CITY OF ALBUQUERQUE

May 2, 2022

Re: **3820 Central Ave SE**
Traffic Circulation Layout
Architect's Stamp 04-23-2022 (K17-D122)

ENCROACHMENT EXHIBIT
LOT 5-A, BLOCK 3
MANKATO PLACE
CITY OF ALBUQUERQUE
BERNALILLO COUNTY, NEW MEXICO
MAY, 2022

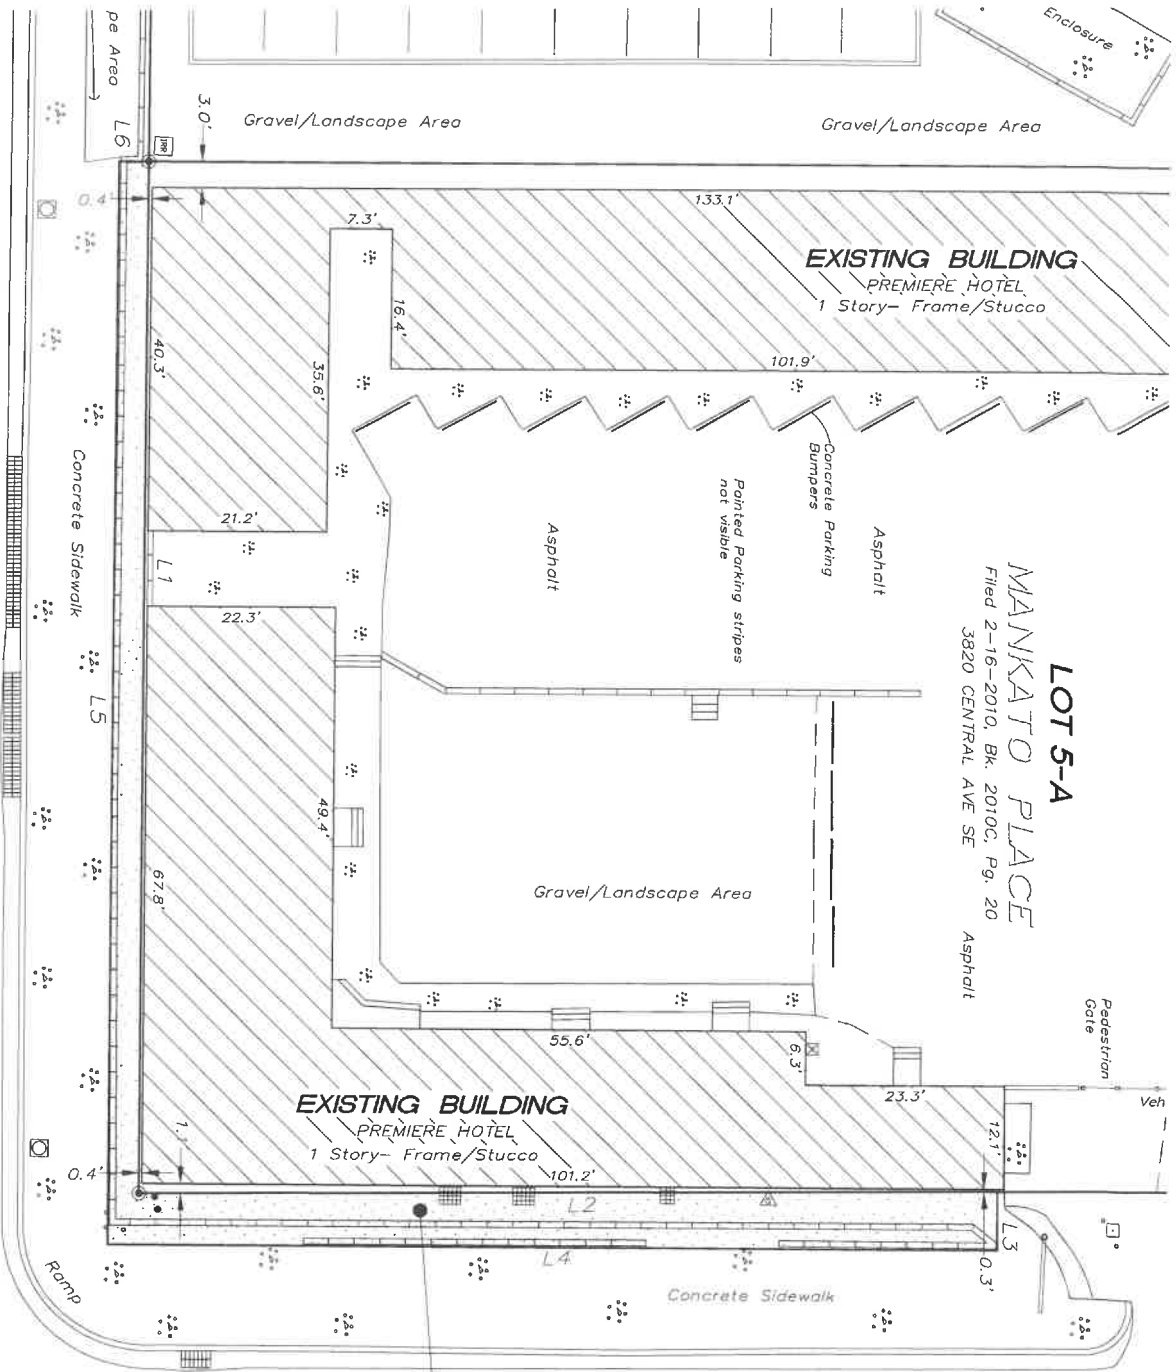
- Extg. Dumpster will need to be located outside of COA ROW on private property.
- **Any private structures that are located within public right-of-way such as fences and walls shall either be removed or else a revocable permit with the City is required in which an annual fee is paid per year, based on square footage of the encroachment.**
- **Existing drivepad/curb cuts not being utilized will need to be closed:** Any private structures that are located within public right-of-way such as fences and walls shall either be removed or else a revocable permit with the City is required in which an annual fee is paid per year, based on square footage of the encroachment.

ENLARGED SITE PLAN

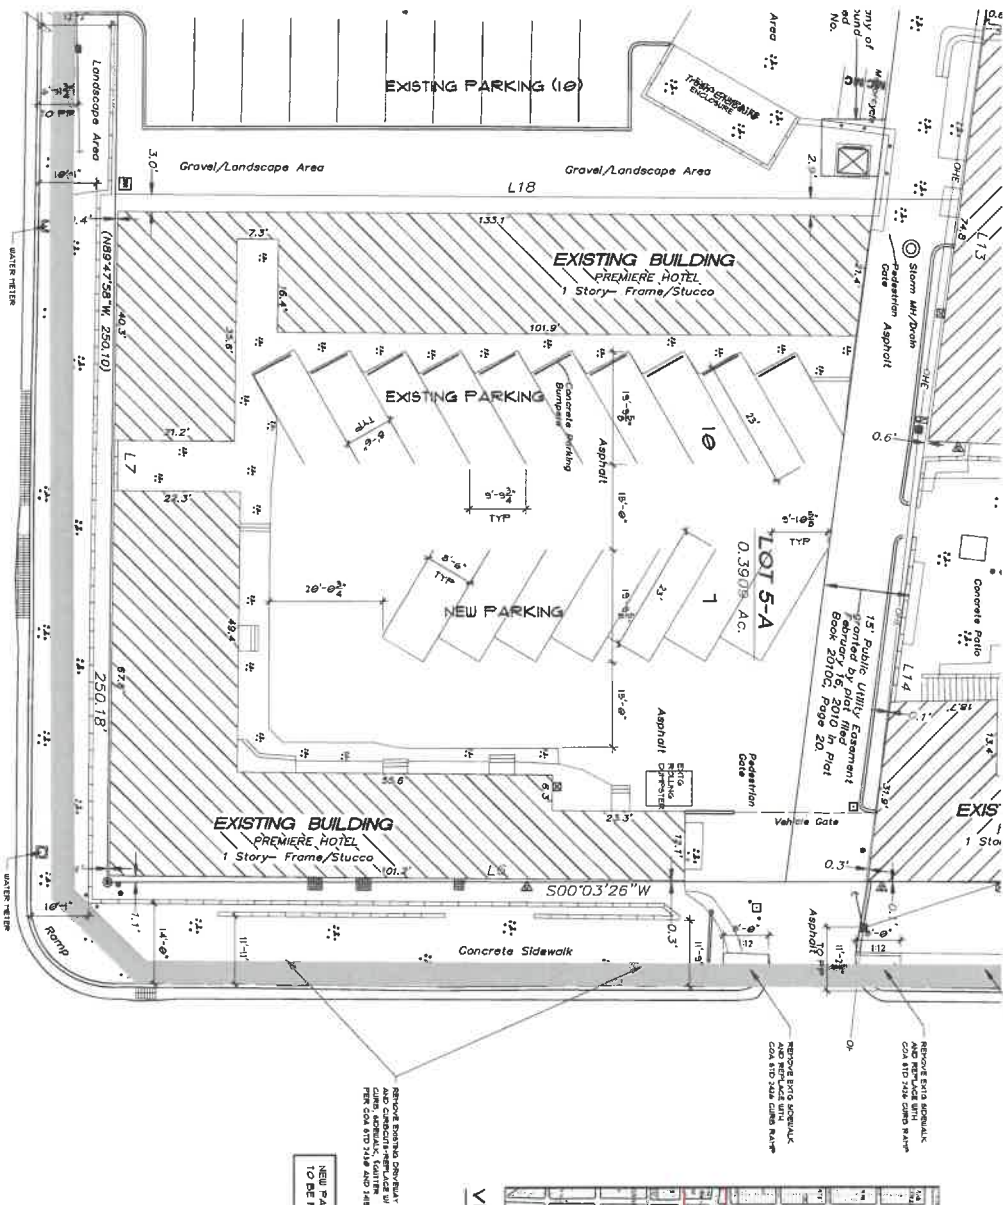
2. **Proposed stall:**

- Per DPM Criteria: Provide the dimensions per the criteria.
- Provide stripin detail (stripe color and thickness).
